AGENDA ITEM: DFT Project Number: PR-2023-008423

Application Number: SI-2023-00606 Project Name: 4821 Pan American West – Lexus

CODE ENFORCEMENT COMMENTS & APPLICANT RESPONSES

Request: Major Site Plan Amendment

PR-2023-008423

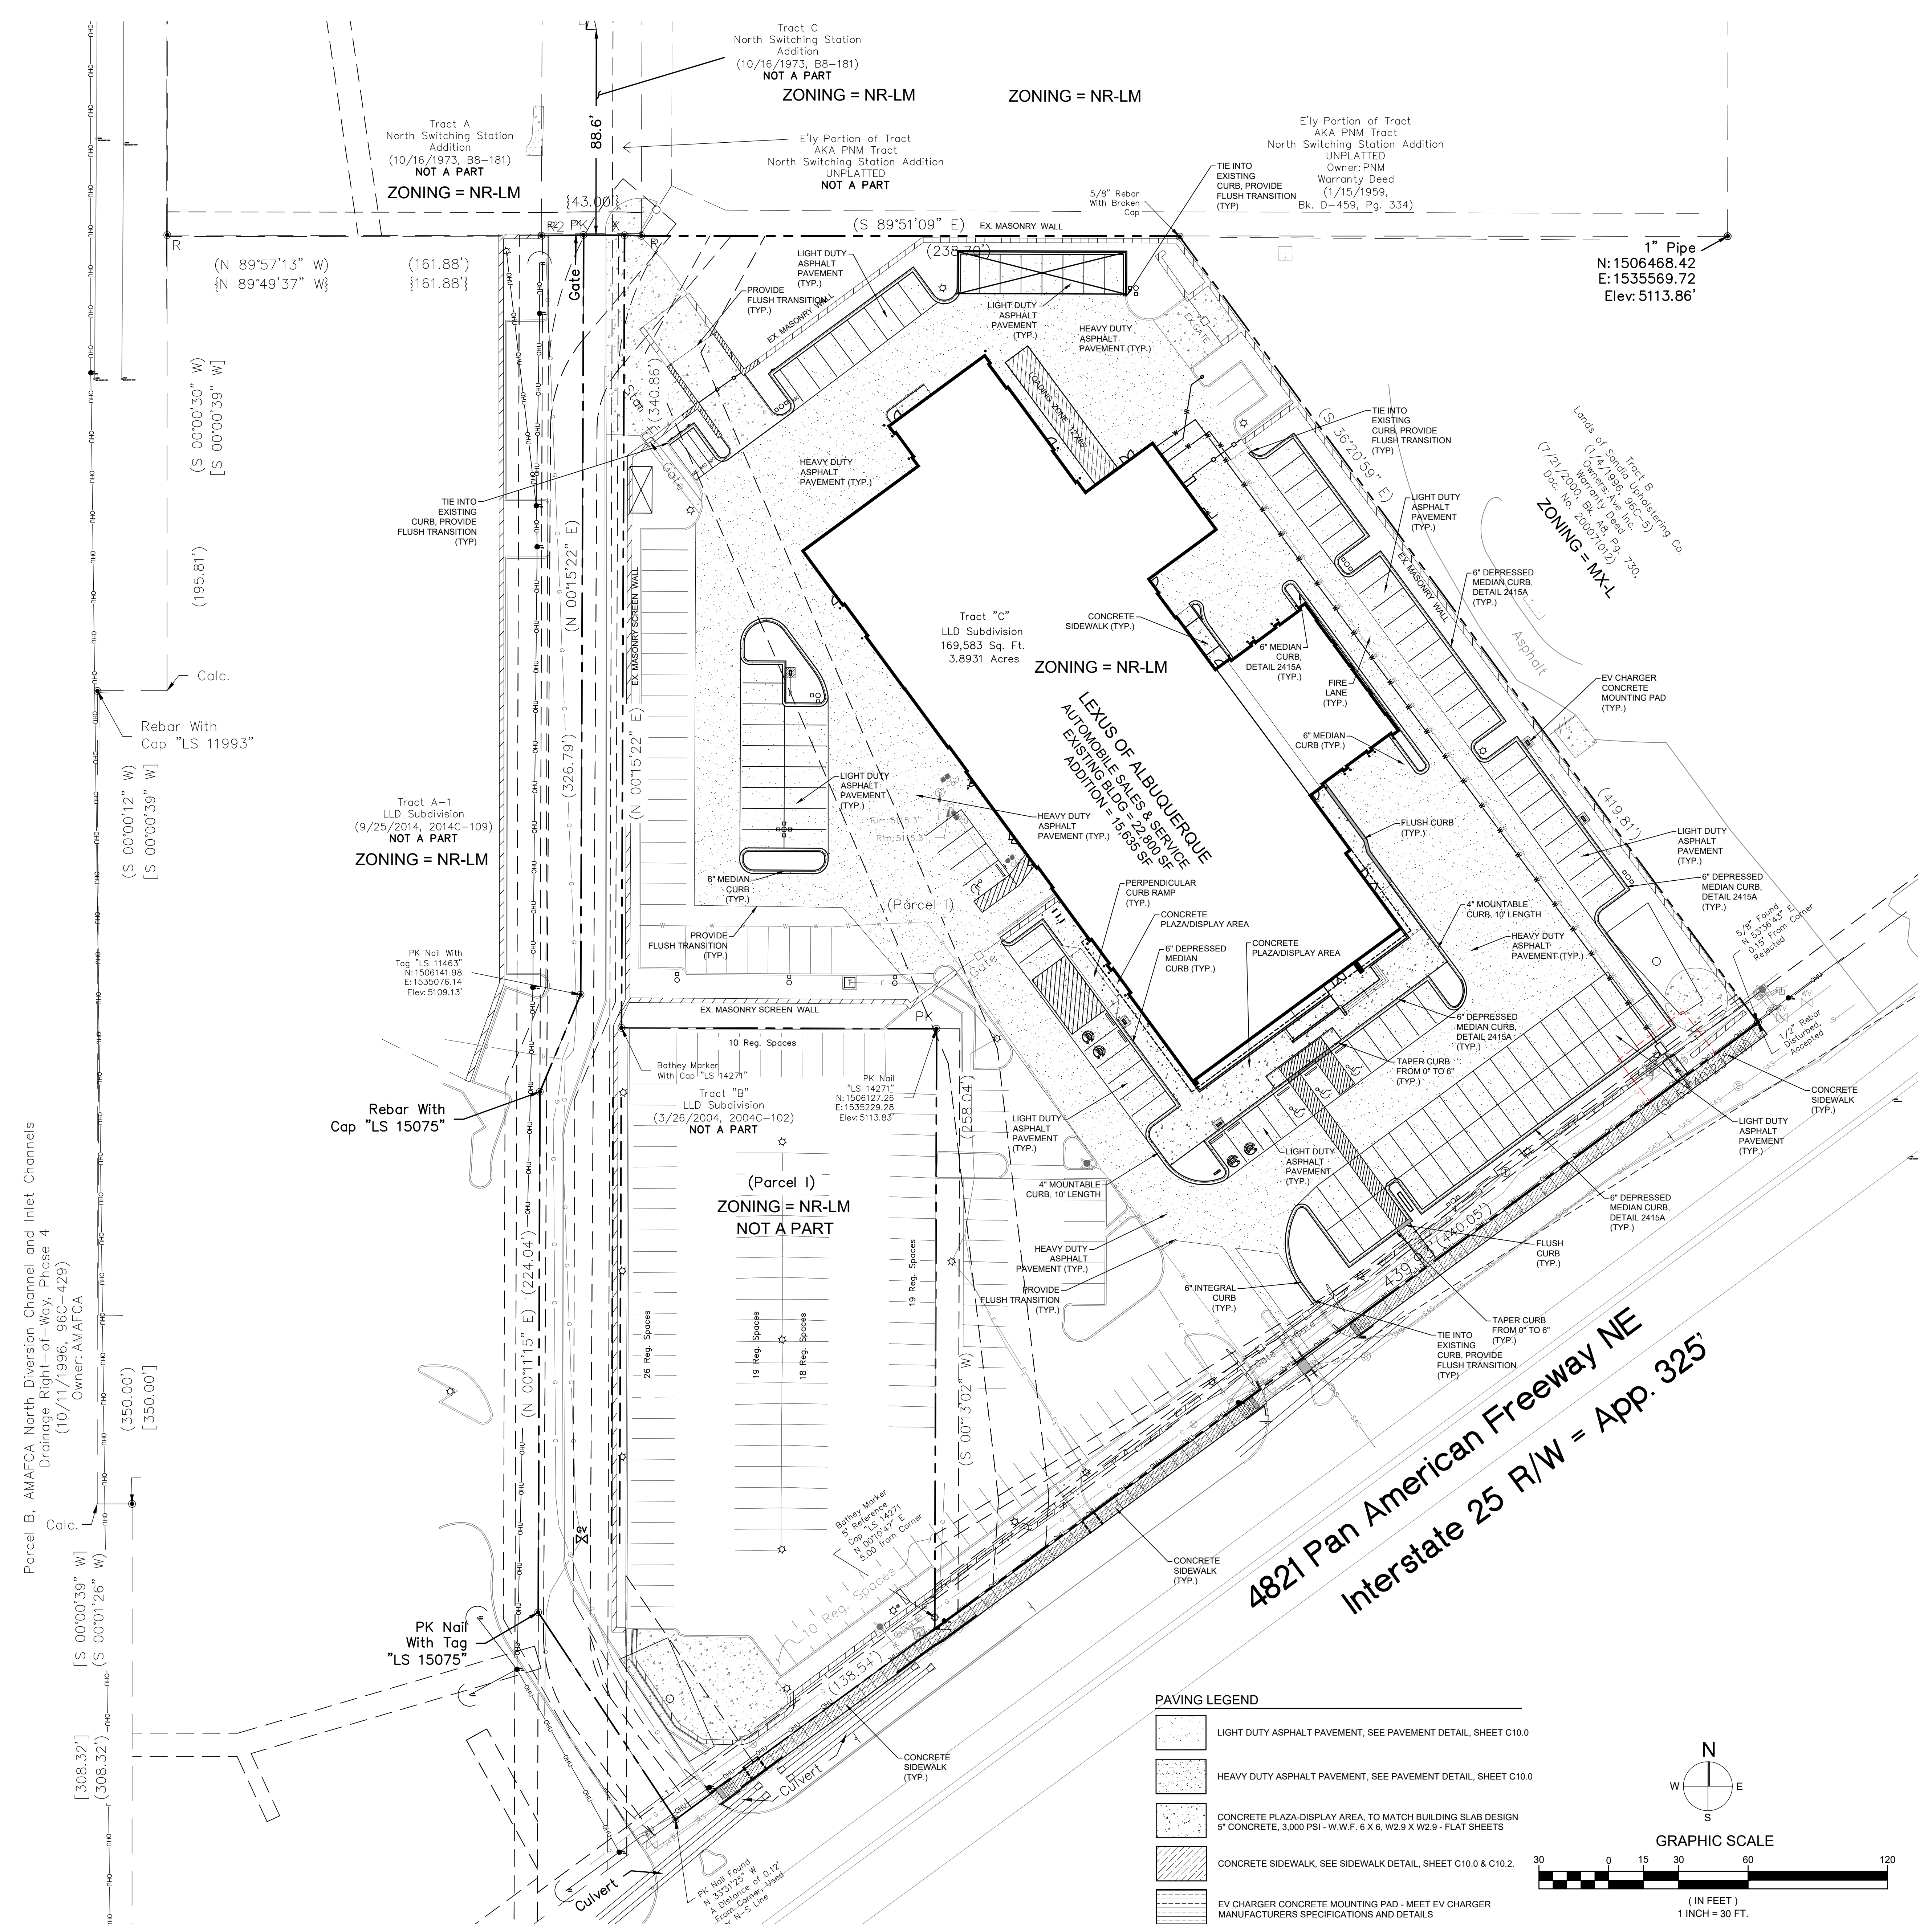
1. Parking along Pan American must be limited to display vehicles only. No spaces within 30 ft of the front lot line can be used or counted towards vehicular parking spaces for customers, unless you install 3 ft tall wall or vegetative screen along the front lot line. You should note and/or mark on the Site Plan that the spaces within 30 ft of the lot line are for vehicle sales display only.

2. Please indicate on site plan which parking spaces are to be utilized/counted towards minimum required for uses on lot. Others may be used for display or additional parking, as needed, but we need to be sure the minimum required are reserved for off-street parking use, as per IDO 5-5(C)(1)(f).

NOTE ADDED TO SITE PLAN, SHEET C02.0.

ALL REQUIRED PARKING SPACES INCLUDE “R” WITH NUMBER SHOWN.

52 REQUIRED PARKING SPACES PER CODE, AND 55 SHOWN AS REQUIRED ON SITE.

SEE REVISED SITE PLAN, SHEET C02.0.

**C04.1**

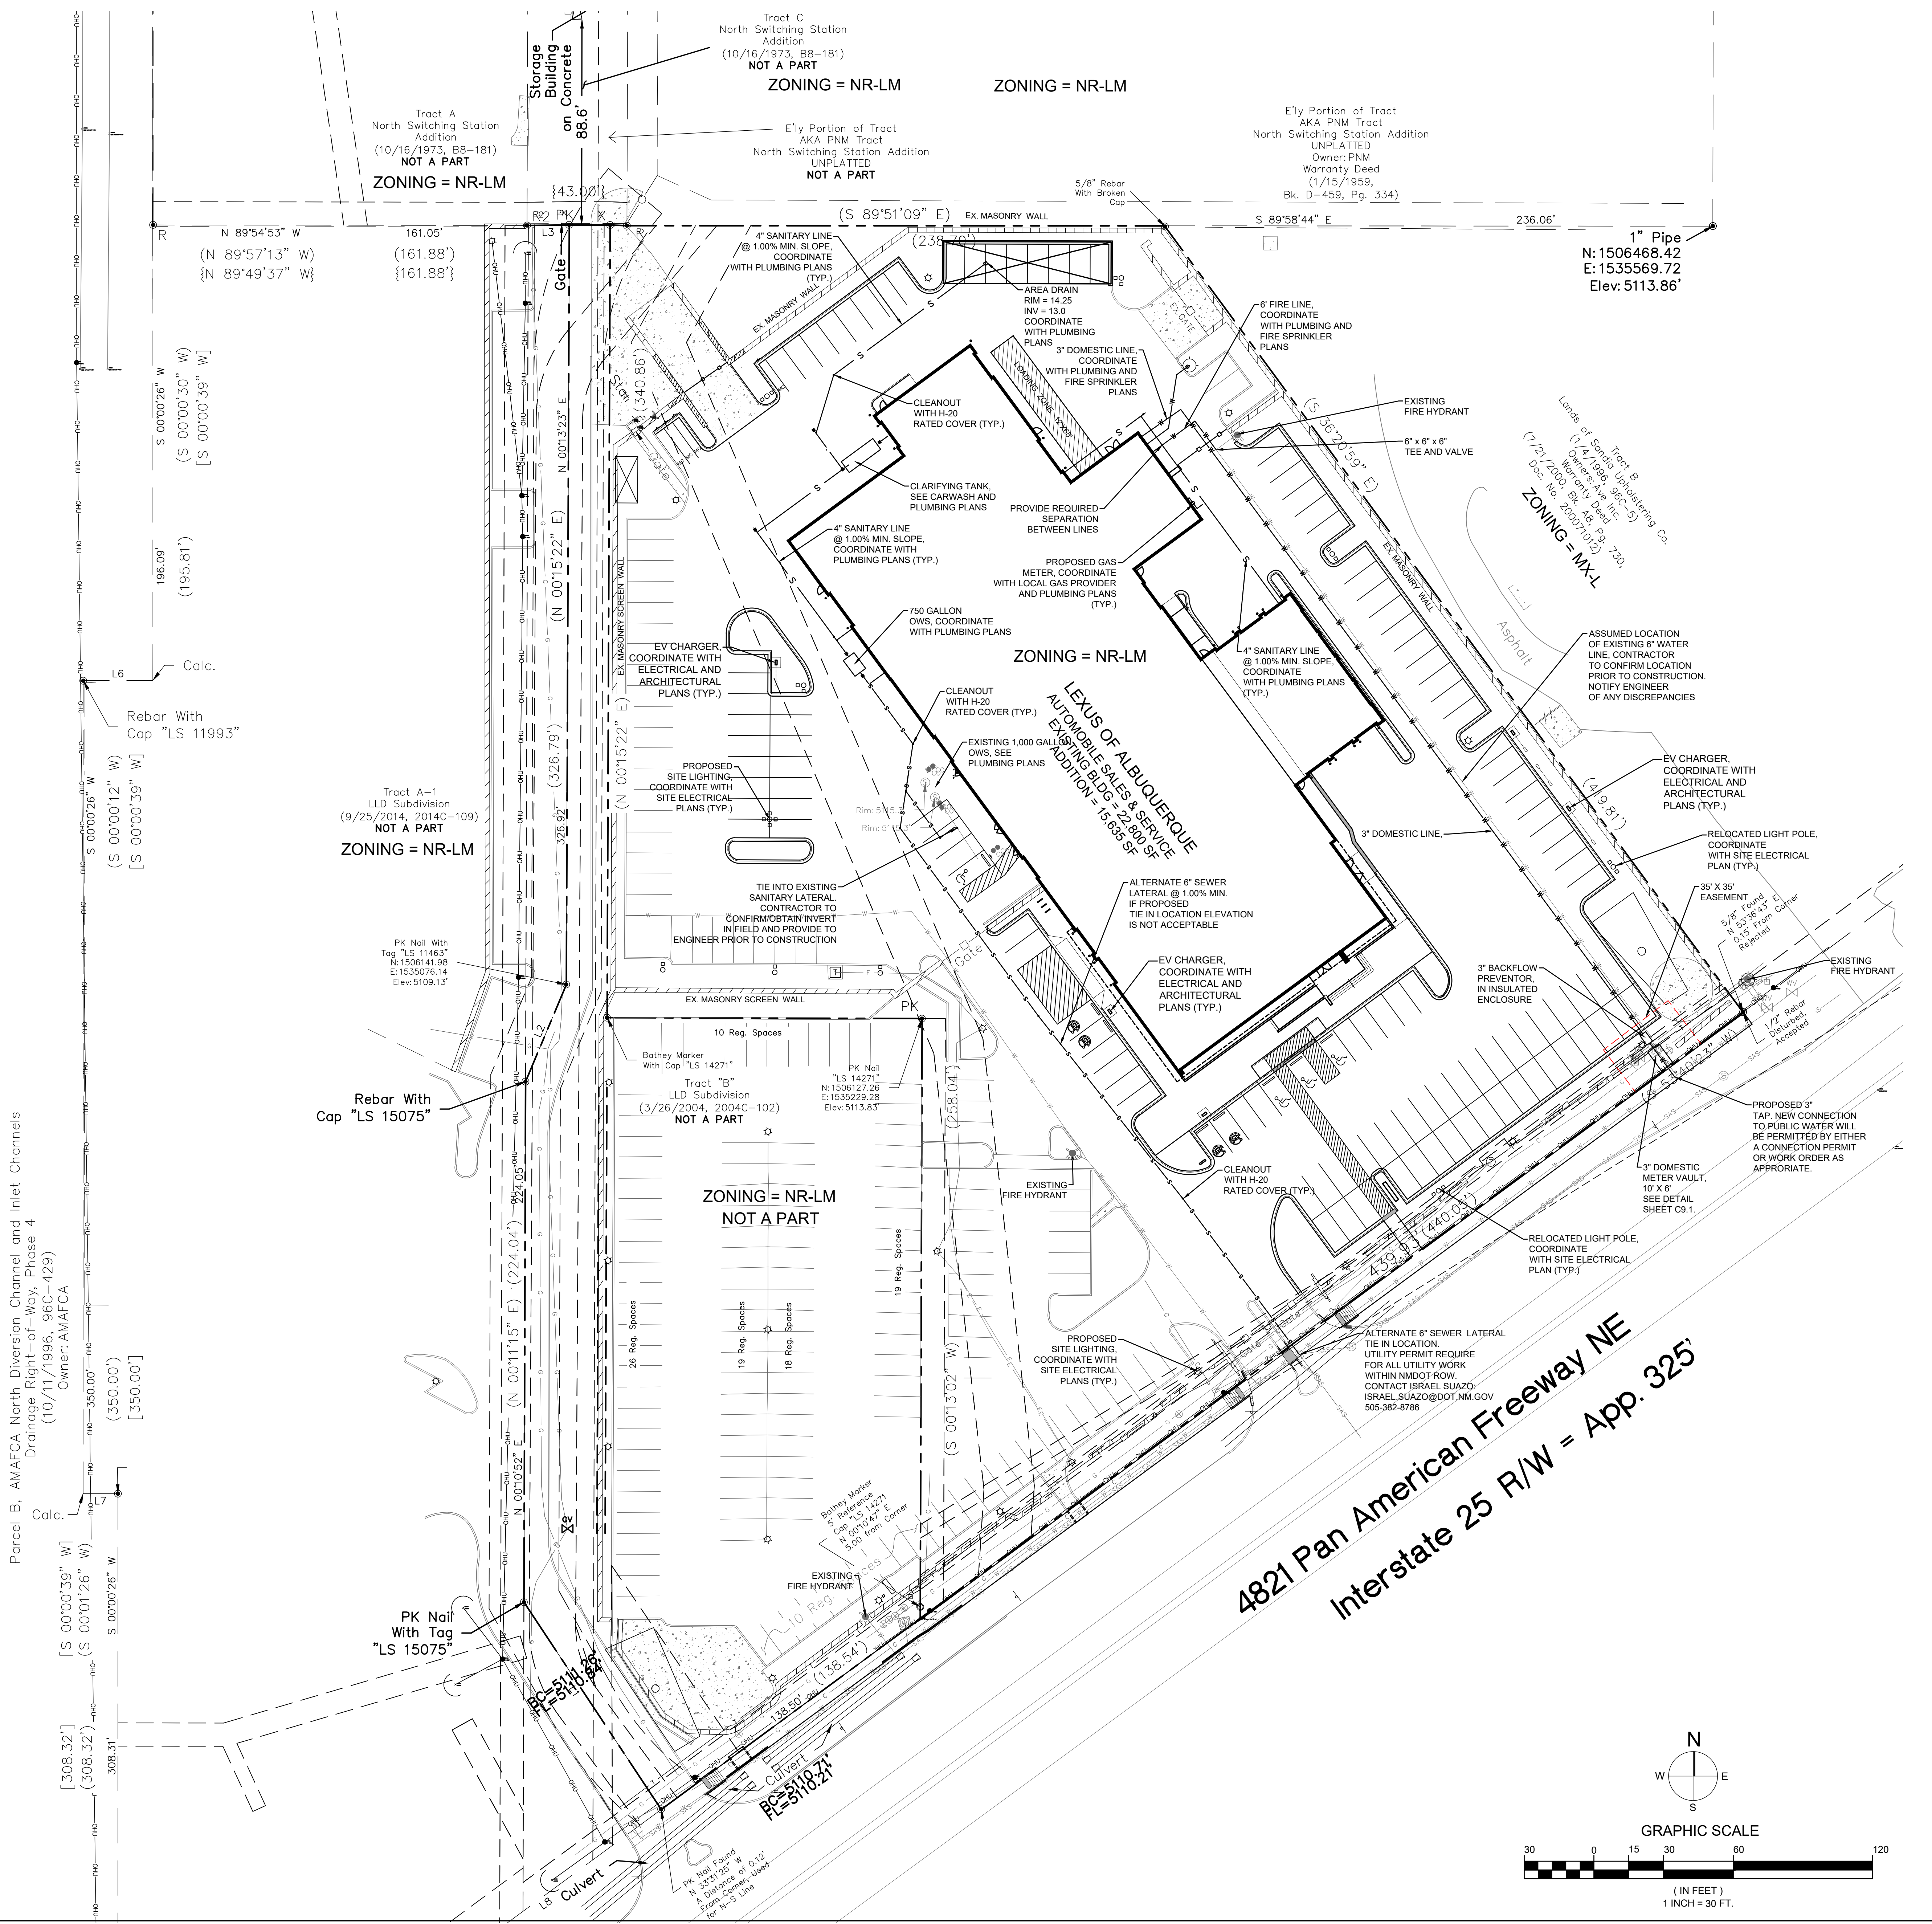
1. Availability Statement 220818 has been issued and provides conditions for service.
2. Utility Plan:
 - a. Please add the following notes to the utility plan
 1. Coordination with Water Authority Cross Connection Section will be required to ensure proper backflow containment is in place prior to release of meter for the site. Contact the Cross Connection Section at 505-289-3454.
NOTE ADDED TO UTILITY PLAN, SHEET C05.0.
 2. Coordination with the Water Authority Pre-Treatment Engineer is required to ensure the site complies with Water Authority Sewer Use Ordinance. Contact the Pre-Treatment Engineer at 505-289-3439.
NOTE ADDED TO UTILITY PLAN, SHEET C05.0.
 - b. Please note on the utility plan that new connection to public water and public sanitary sewer will be constructed by either a connection permit or work order as appropriate.
NOTE ADDED TO UTILITY PLAN, SHEET C05.0.
